TALLAWONG STATION
PRECINCT SOUTH
SSD 10425

RESPONSE TO SUBMISSIONS

DEICORP PROJECTS (TALLAWONG STATION) PTY LTD

January 2021

Status **RF11 for DPIE** Dwg No. **DA-720-020** Rev **05**

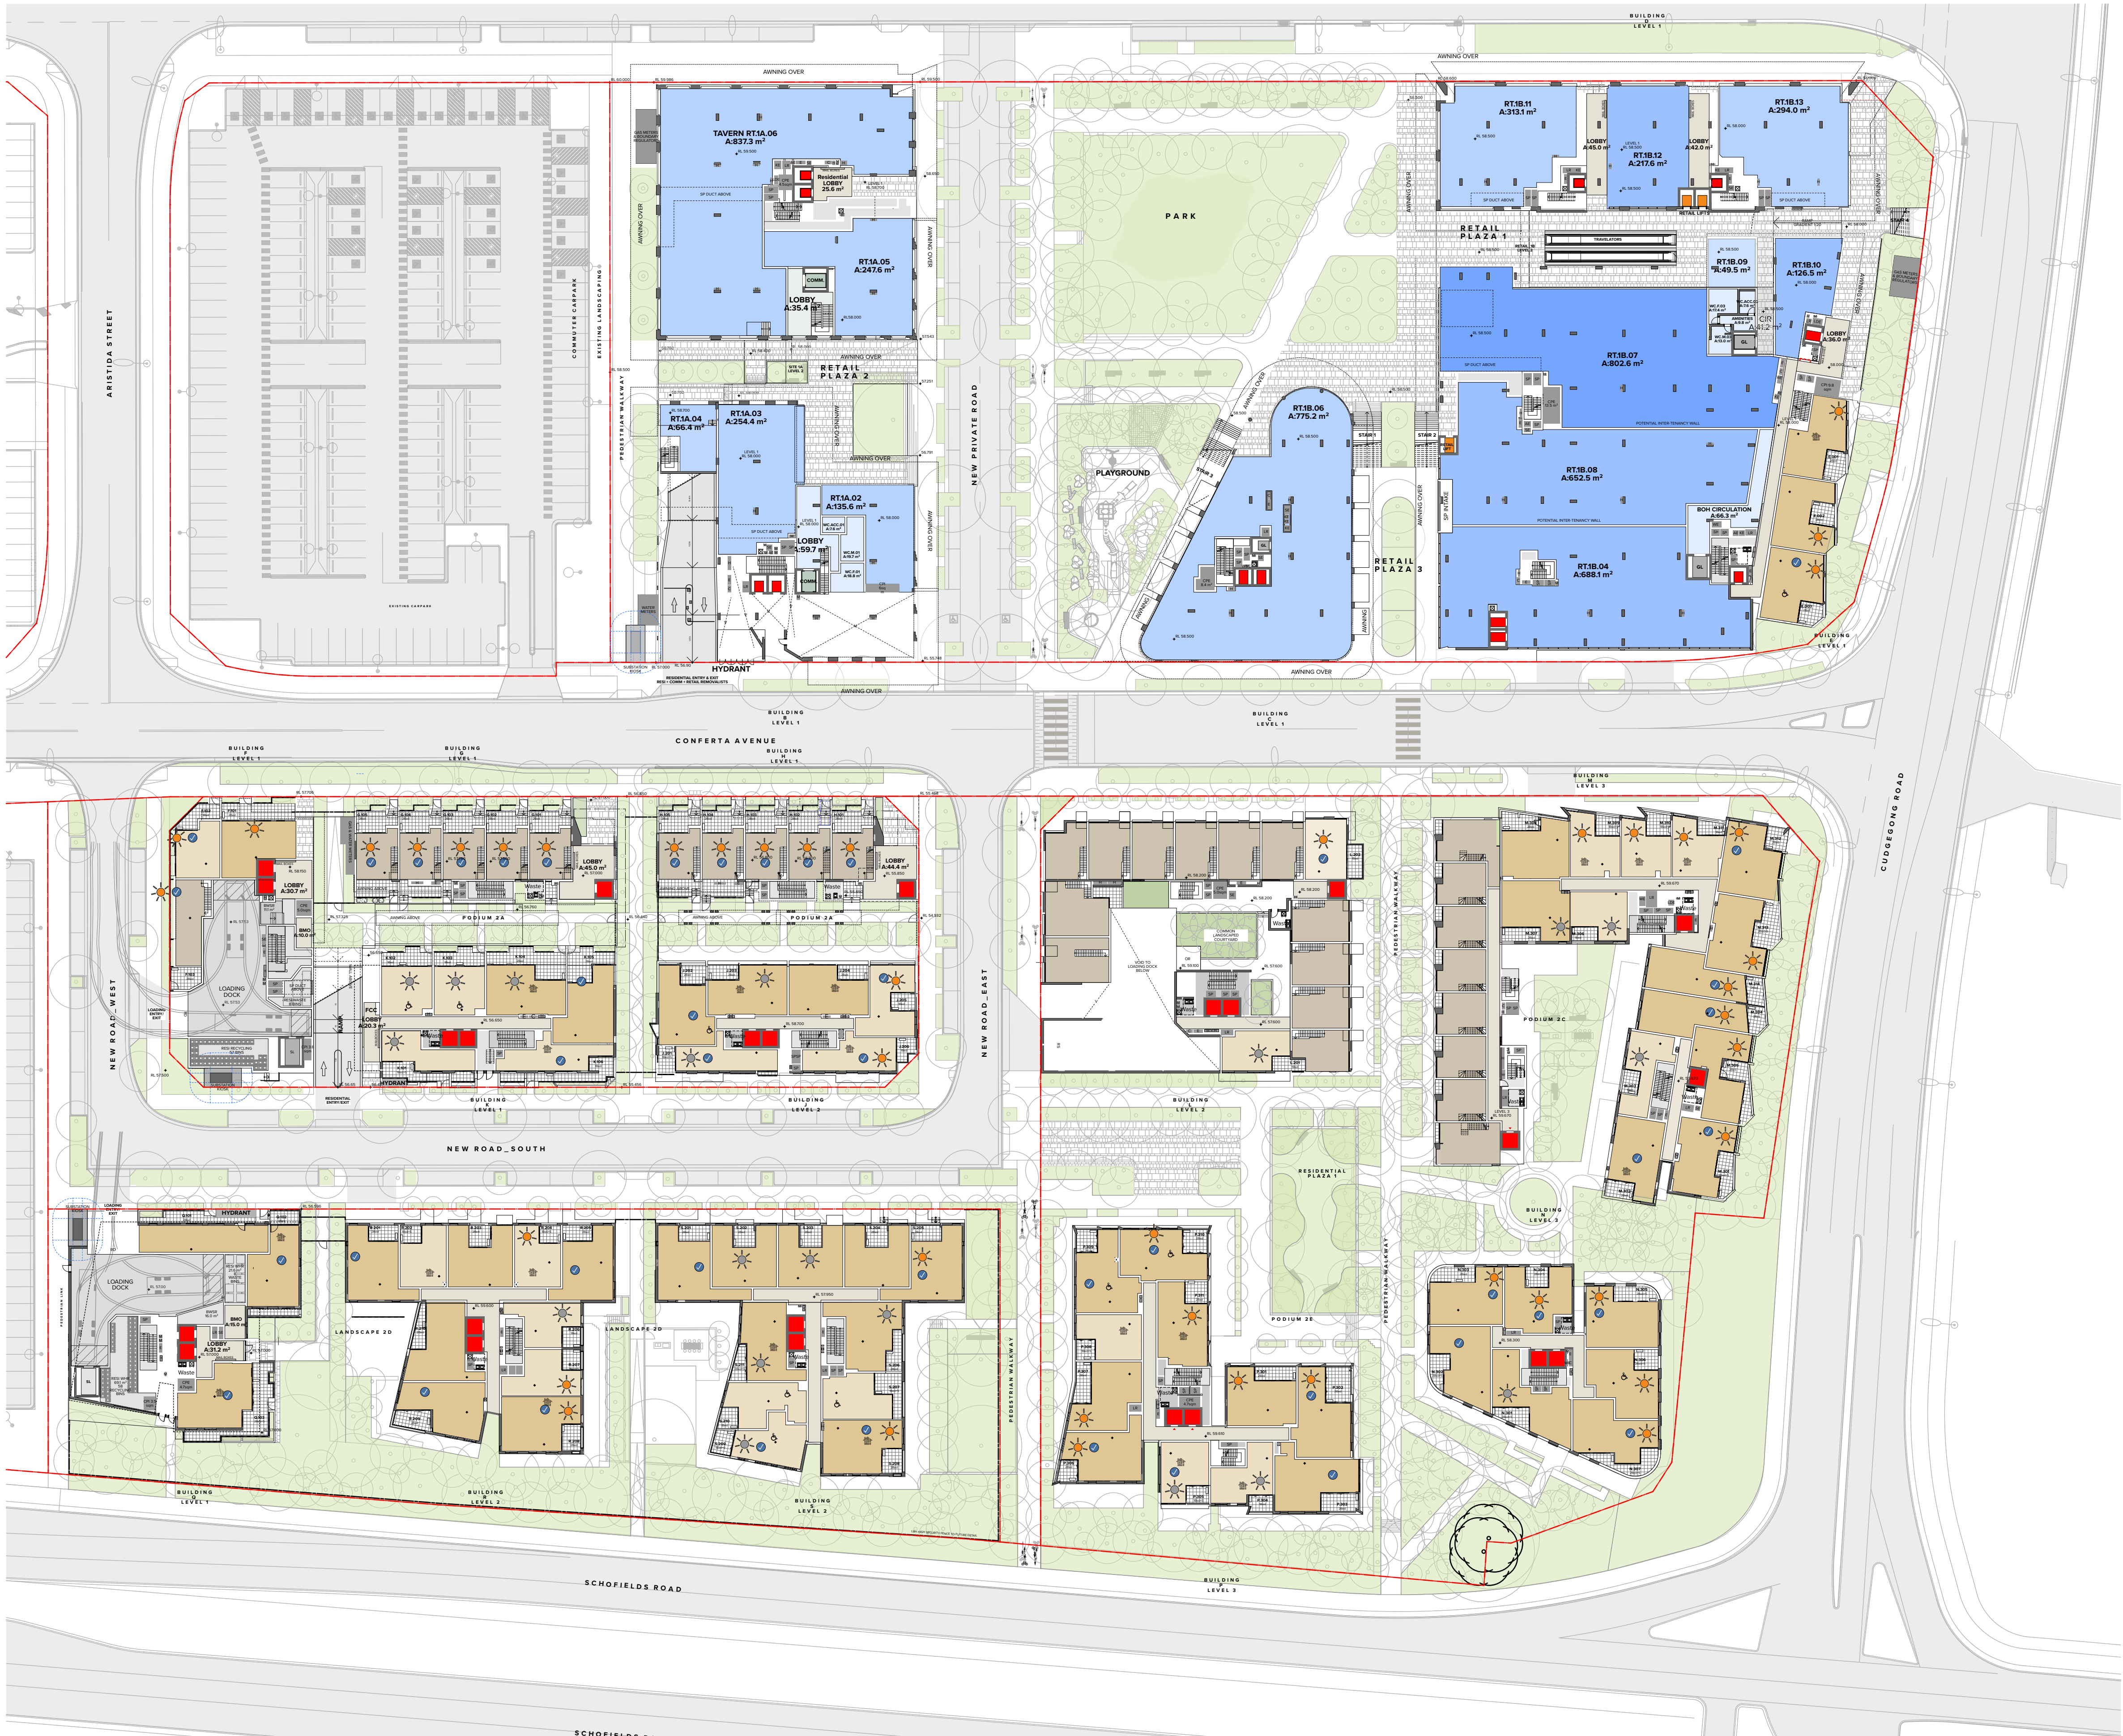
| <p>particularly how solar access and ventilation would be achieved for each of the proposed buildings. This must include (but not limited to):</p> <p>a. solar access diagrams to illustrate how solar access would be achieved for the proposed apartments</p> <p>b. clarify how cross-ventilation and natural ventilation are achieved for apartments affected by rail and road noise.</p> | <p>submitted with the Development Application included solar access diagrams which identifies every apartment of the 987 apartments which achieves compliant solar access. This submission is also accompanied by sun-view diagrams as well as a schedule of apartments which also identify which apartments achieve a compliant level of solar access.</p> <p>In relation to ventilation for apartments affected by noise, it is noted that the Department has recently confirmed in the assessment report for SSD application 7749 at 11 Gibbons Street, Redfern that “the ability to provide natural cross ventilation and acoustic privacy is not mutually exclusive, as both are not required at all times. In noisy periods, windows and doors can be closed to obtain acoustic privacy and appropriate airflow can be supplemented...”. An updated acoustic report prepared by Koikas Acoustics accompanies this submission which provides additional detail in relation to how ventilation is proposed to be supplemented for apartments affected by rail and road noise. In summary, a duct containing a fan will be installed into the external façade of noise affected apartments to supply outside air to the habitable spaces of the apartment.</p> <p>Turner Architect</p> <p>The following attached documents demonstrate the proposal’s compliance with the ADG:</p> <p>‘Solar and Cross-Ventilation Diagrams’ (DA-720-010 – DA-720-110).</p> <p>‘Views from Sun’ (DA-715-001 – DA-715-007)</p> <p>‘18095_Development Schedule’ listing solar access and cross ventilation compliance.</p> <p>To address noise issues for apartments facing Schofields Road, windows have been added to the niche in buildings Q, R and S. These windows provide alternative ventilation if the window facing Schofields Road is closed.</p> | <p>Appendix 7</p> <p>Appendix 9</p> |

| | <p>demonstrates solar access to apartments, communal open space and the public realm: ‘Views from Sun’ (DA-715-001 – DA-715-007) The following attached documents demonstrate the ADG solar access compliance for apartments: ‘18095_Development Schedule’ ‘Solar and Cross-Ventilation Diagrams’ (DA-720-010 – DA-720-110).</p> | |
